CITY OF ALBUQUERQUE

**RE: Pacific Mutual Door and Window - Tract 1, Lands of L.A.
Paving, Grading & Drainage Plan
Engineer's Stamp Date 3-5-15 (File: C17D005)**

Based upon the information provided in your submittal received 3-6-15, the above referenced plan is approved for Grading and Paving Permit, and SO-19 Permit with the following comment:

CITY OF ALBUQUERQUE PUBLIC WORKS DEPARTMENT	
TITLE: PACIFIC MUTUAL DOOR & WINDOW PAVING & GRADING AND DRAINAGE PLAN	
DESIGN REVIEW COMMITTEE	CITY ENGINEER APPROVAL
LAST DESIGN UPDATE	MO./DAY/YR.
CITY PROJECT NO.	ZONE MAP NO. C-17-Z
SHEET 1 OF 1

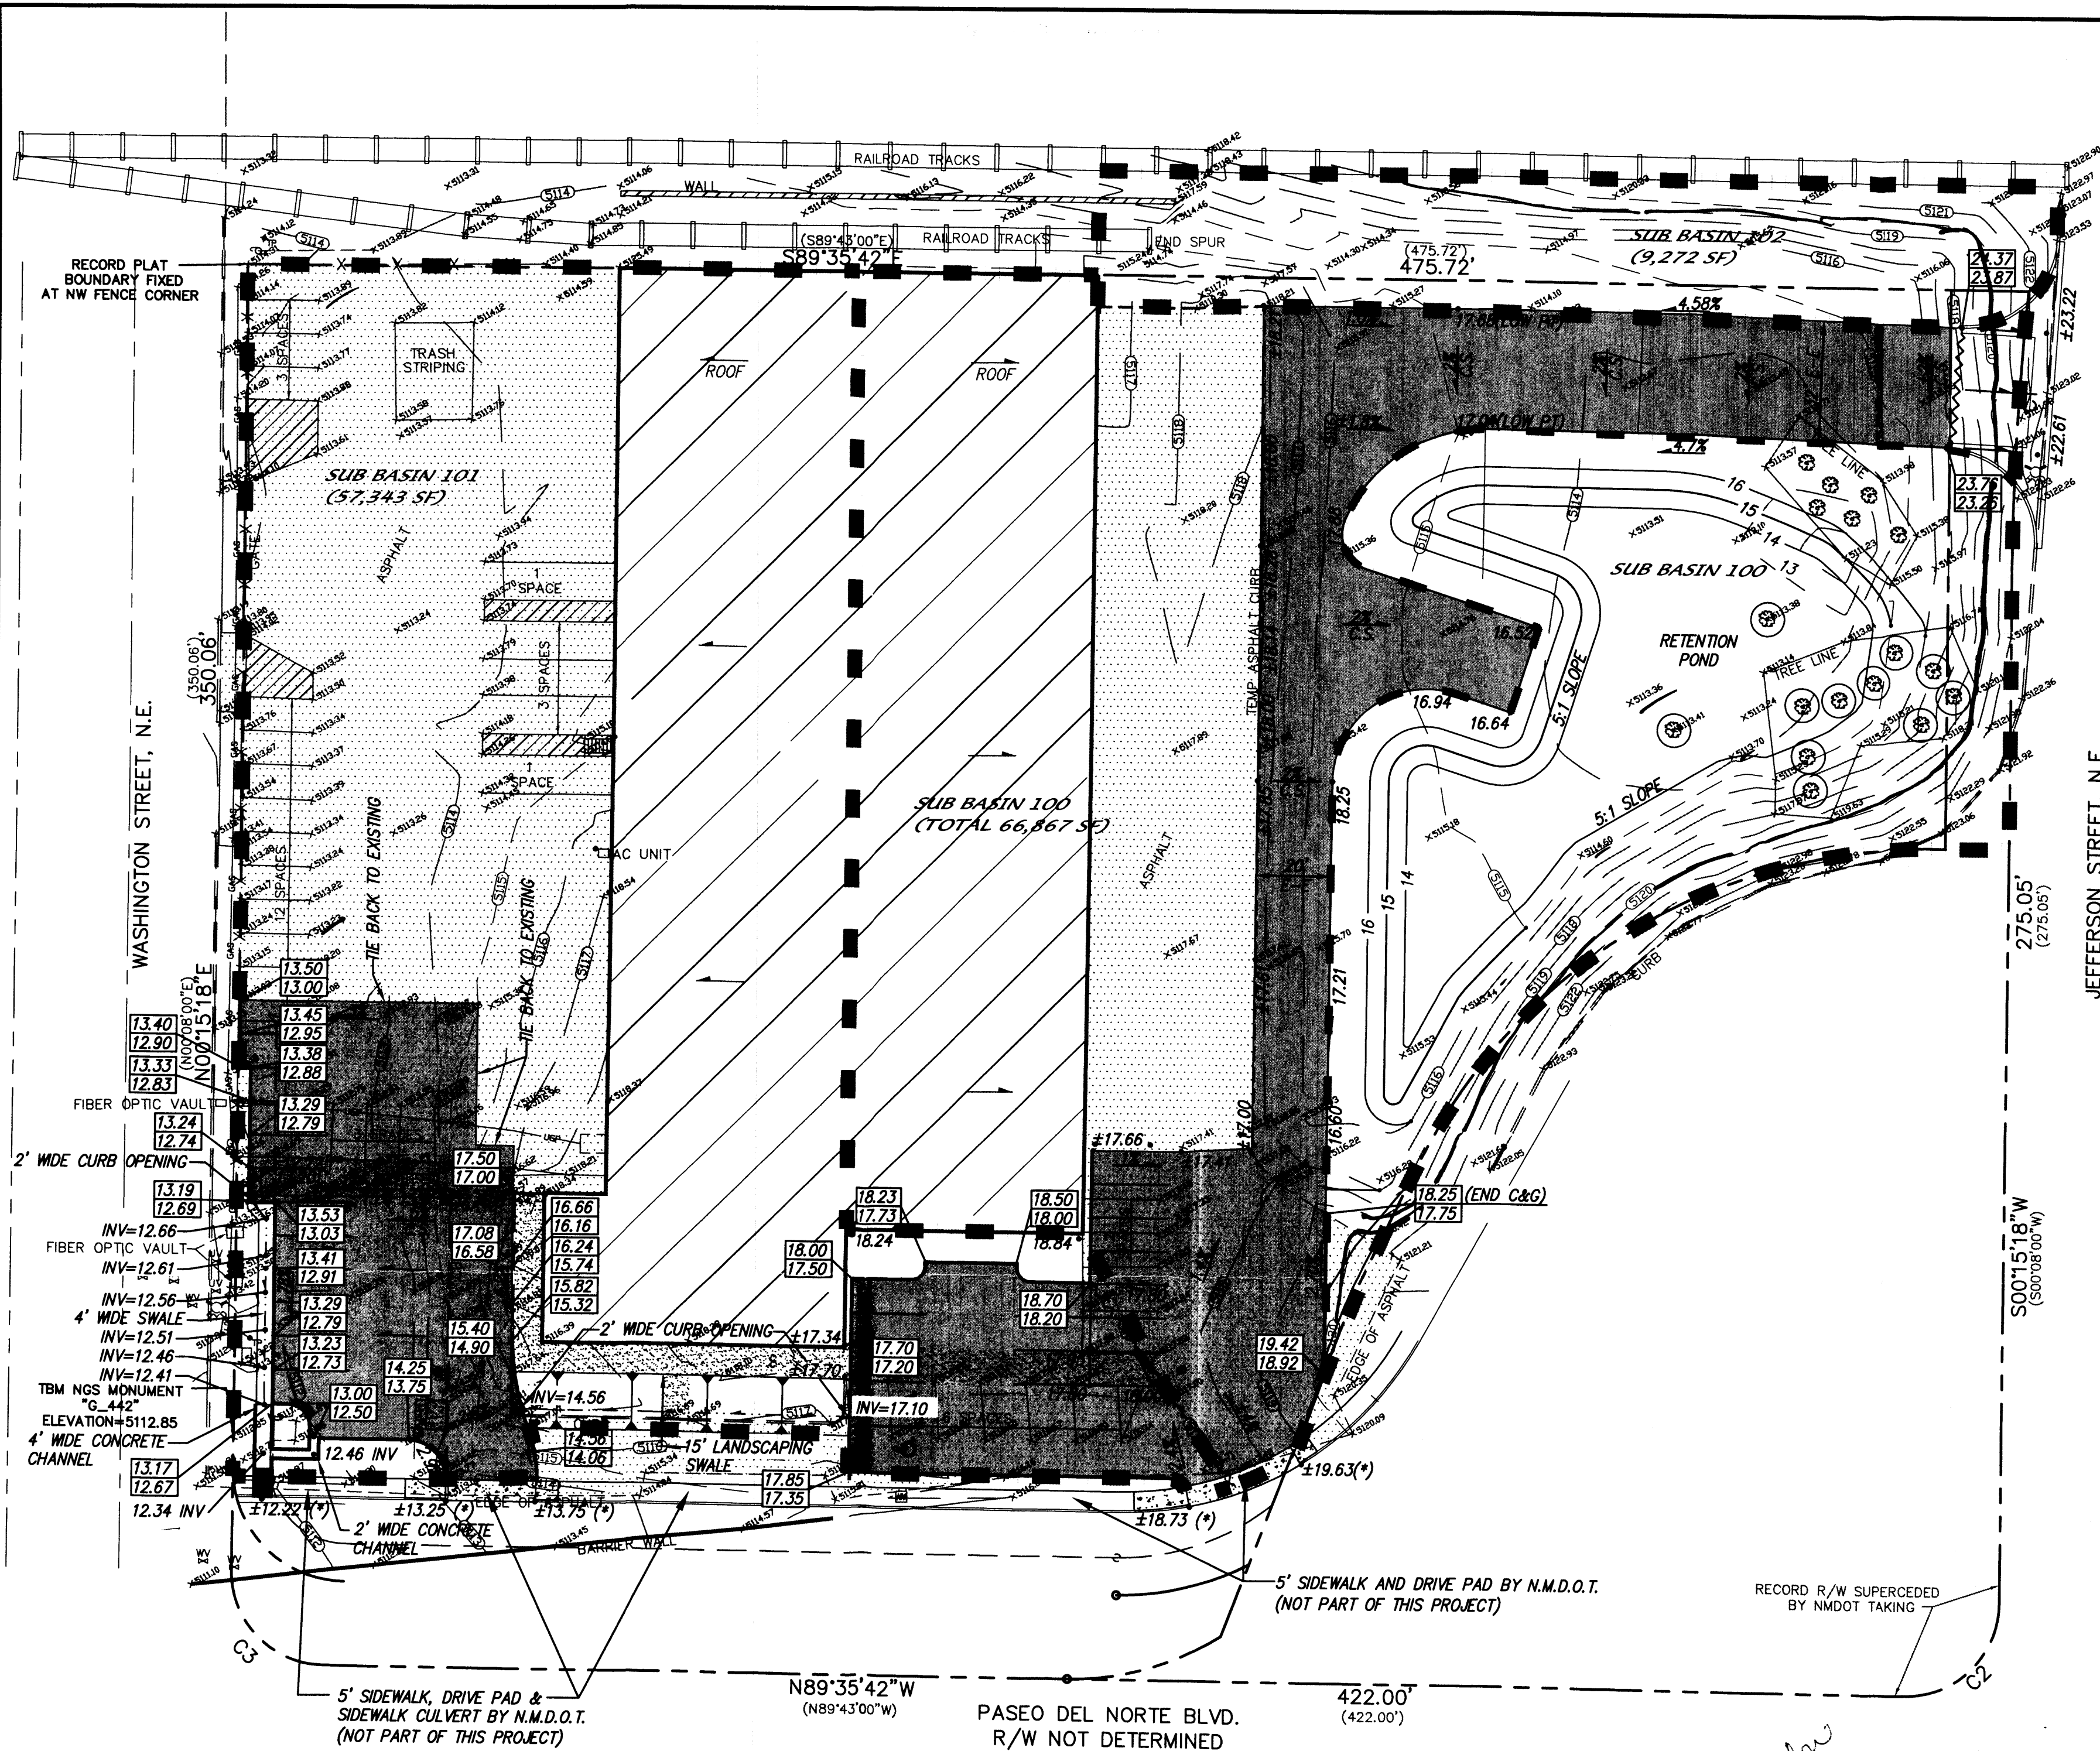
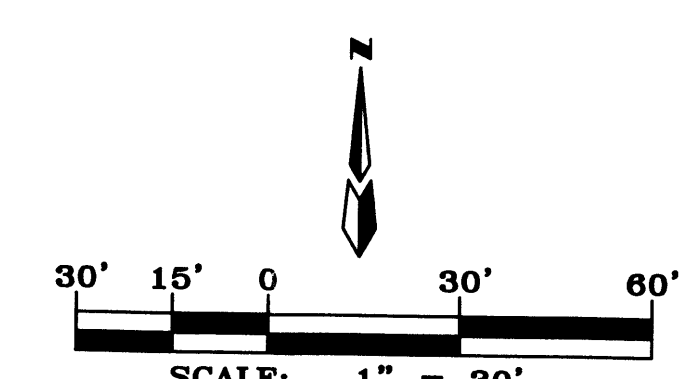
1. Indicate the Emergency overflow path as discussed – ~~through the swale along the south side of property.~~
